Recommendation Report for Planning Permission for Works or Extension to a Dwelling

REF NO: R/157/20/HH

LOCATION: 70 Sea Avenue
Rustington
BN16 2DJPROPOSAL: Hipped roof to gable end to west elevation. Roof dormer to north elevation.
Pitched roof to replace flat roof to existing dormer to east elevation and external
and internal alterations.**SITE AND SURROUNDINGS**

Drawing No. 220/598/5

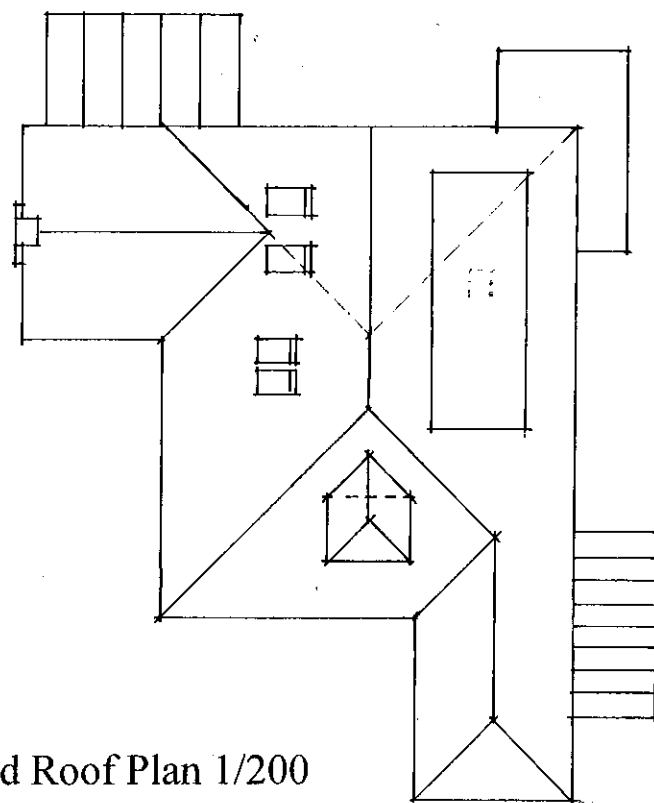
No Objection providing the dormer window to the north is obscure glazed.

The significant size of the proposed dormer on the north elevation is noted, however, due to its siting on the host dwelling, it will only be partially visible within the street scene so that it will not have a demonstrable impact on the street scene as is the case to the smaller dormer on the front elevation.

There is one window proposed on the Northern elevation of the proposal, with potential for views towards the adjacent dwelling, this window will be conditioned to be obscure glazed and fixed to be non-opening below 1.7m.

- 3 The proposed windows at first floor level in the Northern elevation of the building as shown on drawing number 220/598/5 shall at all times be and remain glazed entirely with obscure glass and non opening to 1.8m from the finished ground floor.
